OBSERVATION/SUBMISSION TO PLANNING APPLICATION

Case Reference: 324113

Re: Observation to the proposed development of open-cycle gas turbine (OCGT) and generator with ancillary equipment.

Location: Pollnagroagh and Rathmorrissy (Townlands), Athenry, Co. Galway

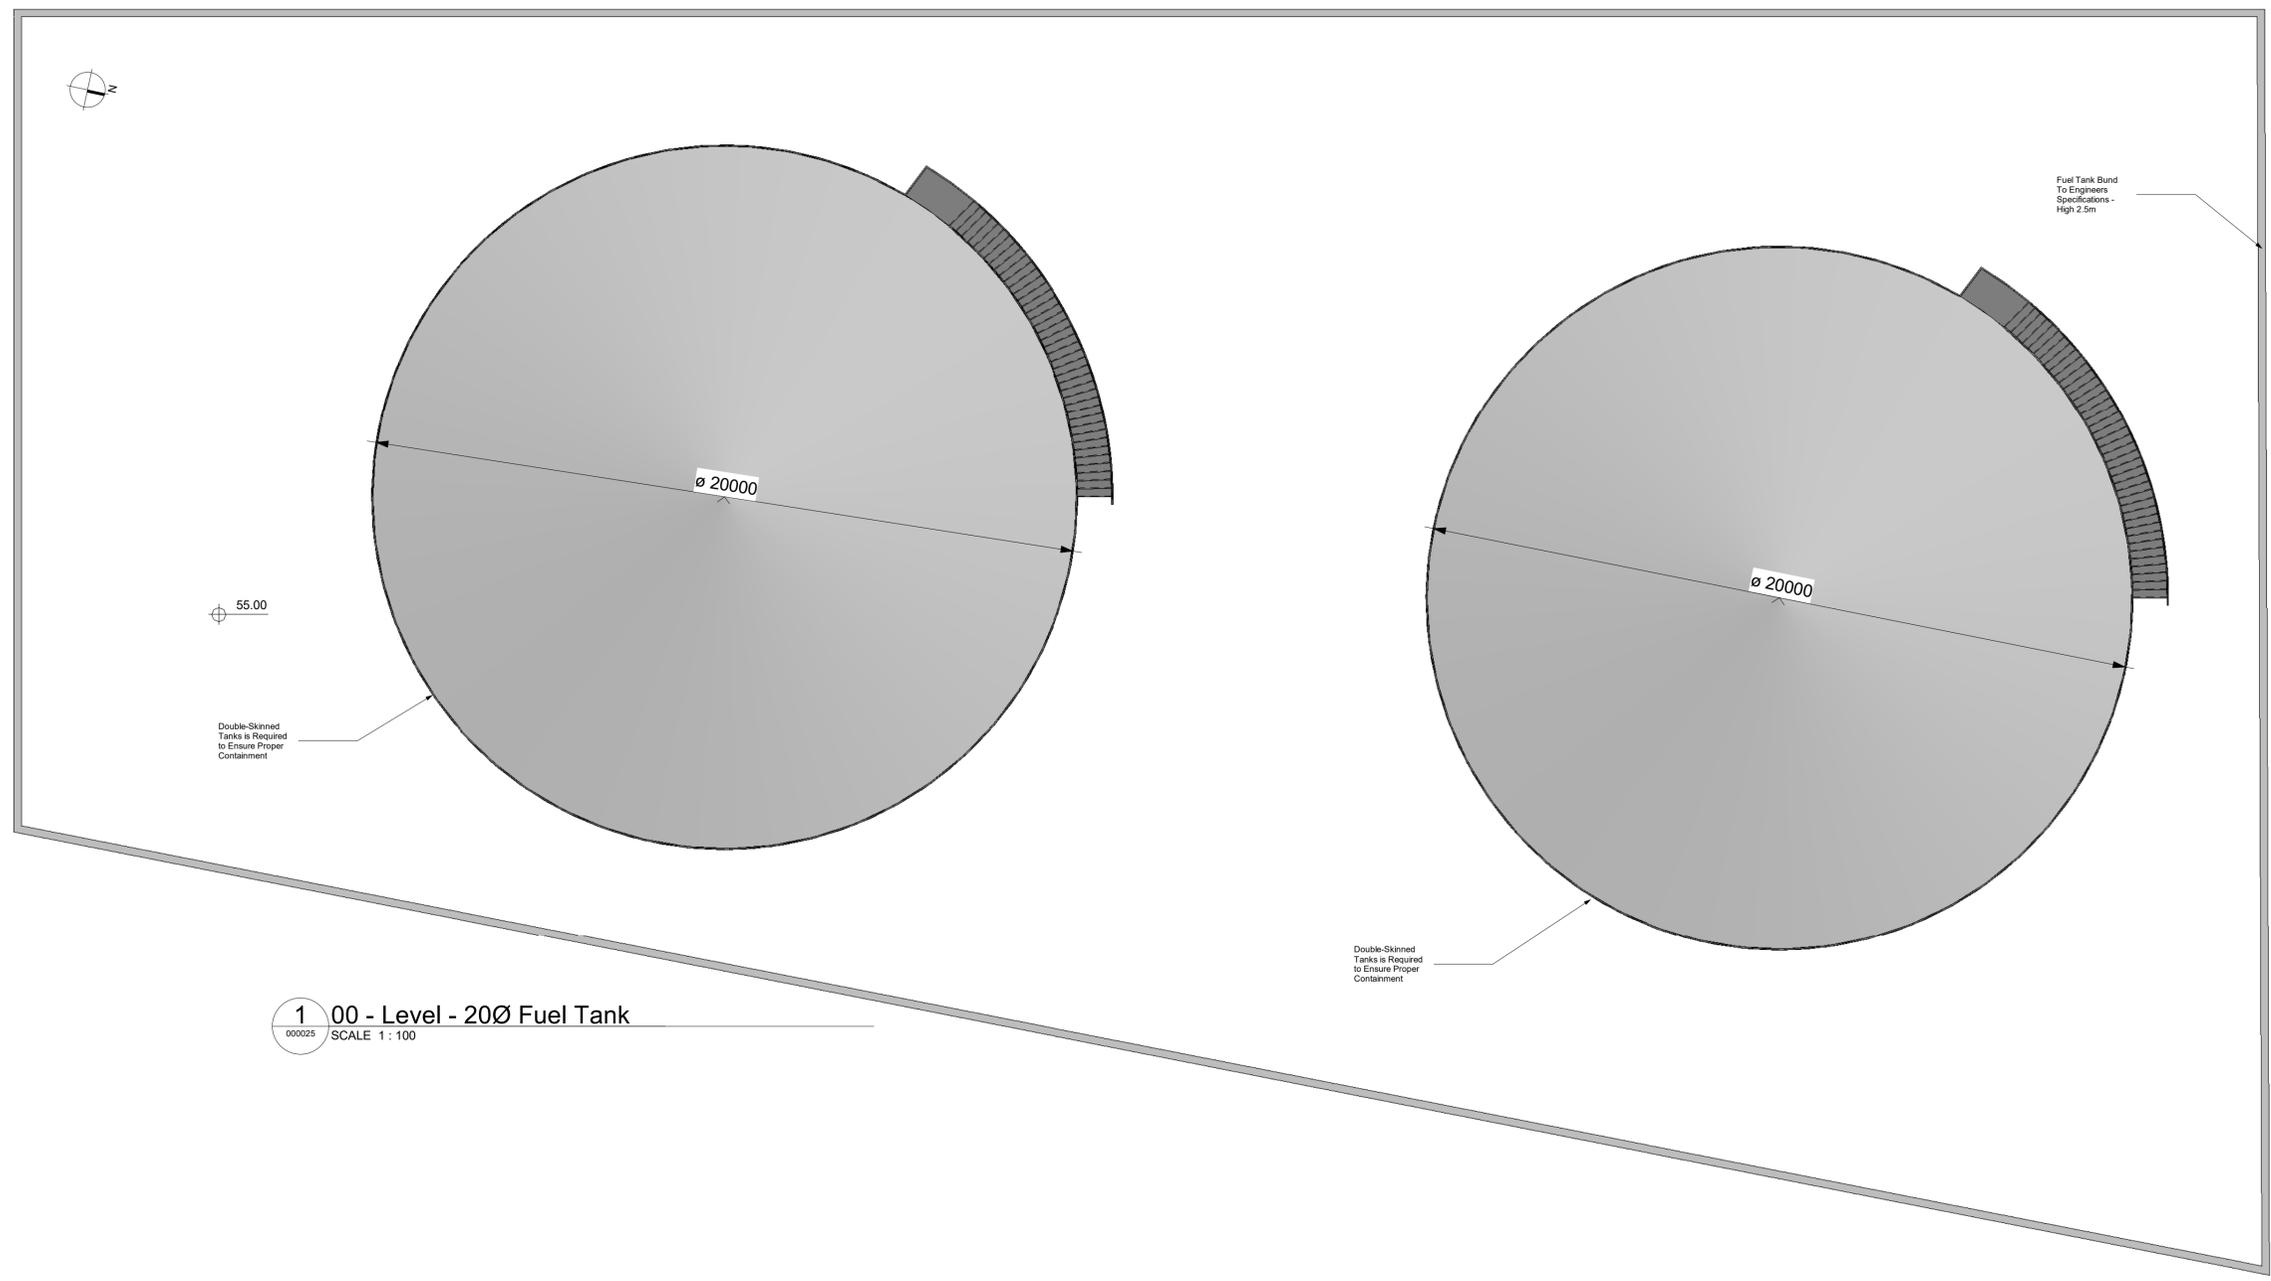
A peaker plant requires the storage and handling of fuels such as diesel, lubricating oils, and other chemical substances, all of which present potential contamination risks. These substances may enter the ground through leaks, spills, or contaminated surface runoff, particularly over the long operational lifespan of the facility (until at least 2050). Even minor but repeated incidents can lead to the gradual accumulation of pollutants in soil and groundwater. Once groundwater contamination occurs, it is extremely difficult and costly to remediate, and impacts can persist for decades. This raises serious concerns under Directive 2000/60/EC, which requires the protection of water bodies and the prevention of deterioration in water quality.

Purpose		PLANNING			
Title		SITE ACCESS SIGHTLINES			
Original Scale	Design/Drawn	Checked	Authorised		
SHOWN at A1	PS	ND	AJB		
Date	Date	Date	Date		
01.12.25	01.12.25	01.12.25	01.12.25		
Status	Drawing Number	Rev			
A2	PEK3-ATK-ZZ-01-DR-CE-901200	0

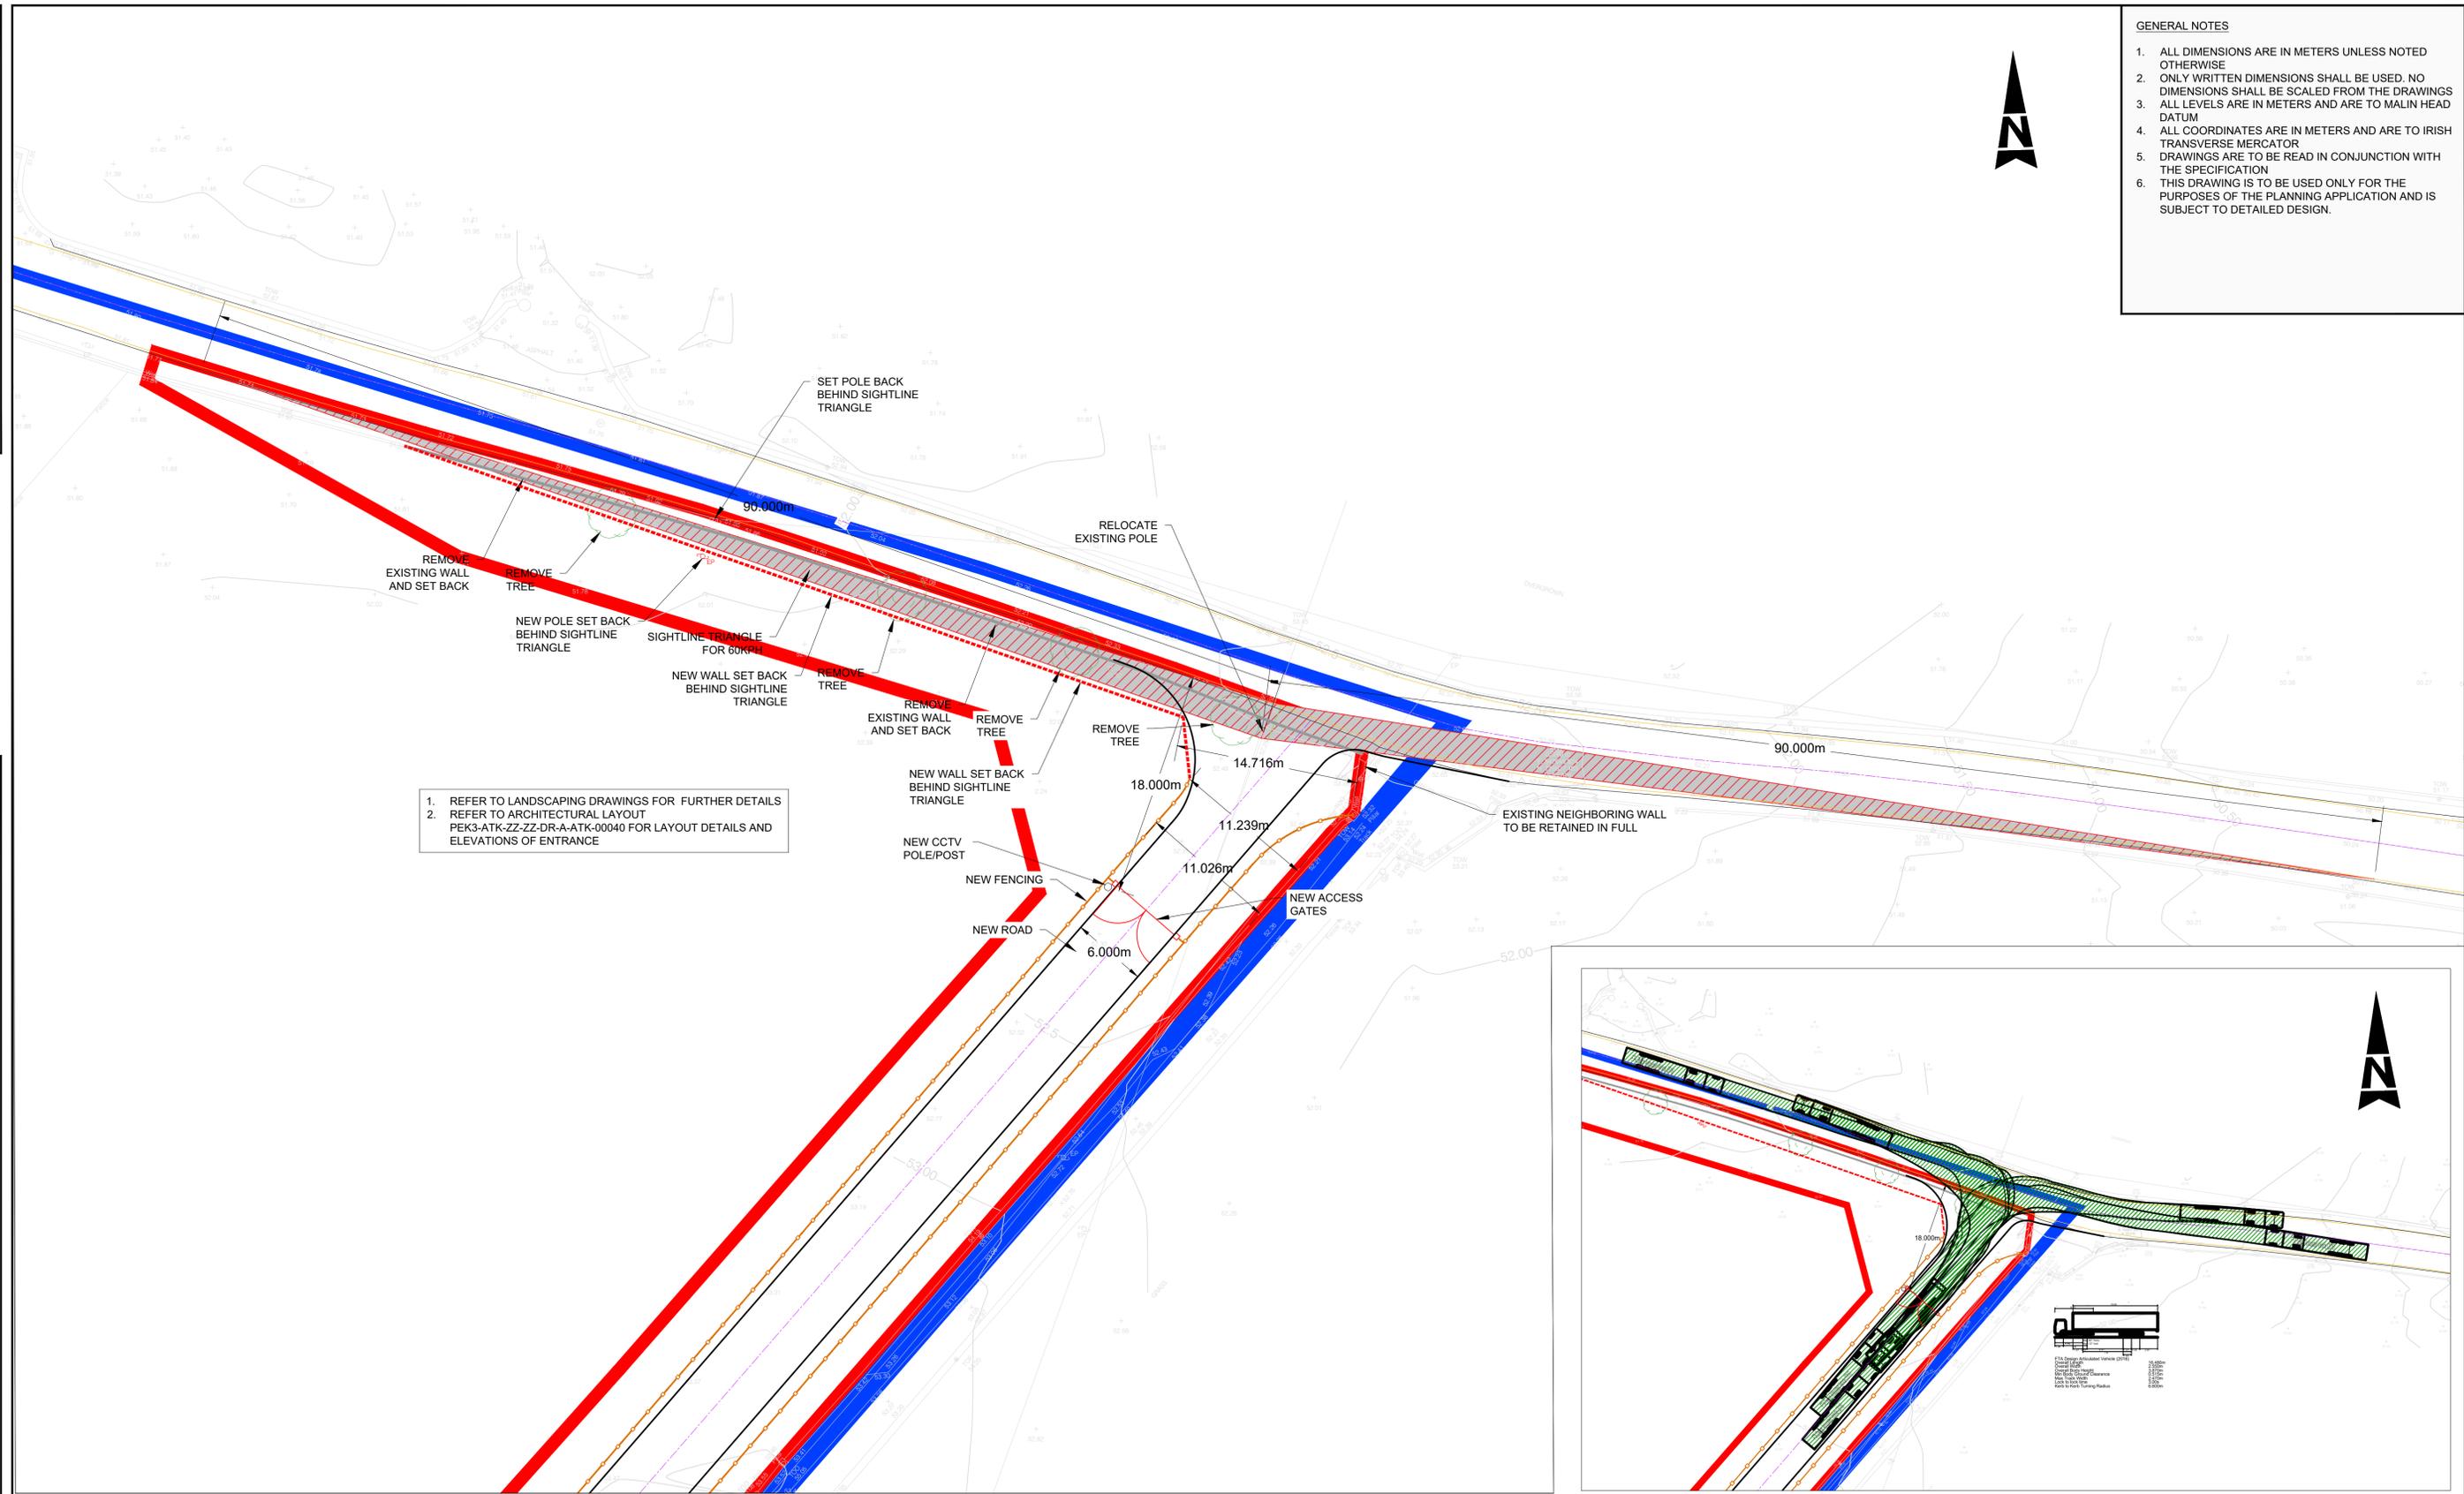
The proposed site entrance is located on an exceptionally dangerous section of the L3103. Establishing an access point at this specific location introduces an unacceptable level of risk due to several compounding hazards:

- Severely Restricted Width: The road is currently too narrow to safely permit two Heavy Goods Vehicles to pass simultaneously.
- Absence of a Hard Shoulder: There is no safe refuge or margin for error for manoeuvring vehicles.
- Critically Poor Visibility: The immediate area is affected by blind dips and blind corners, severely compromising driver sightlines.

These immediate dangers constitute a severe threat to public safety and require urgent and mandatory remediation.
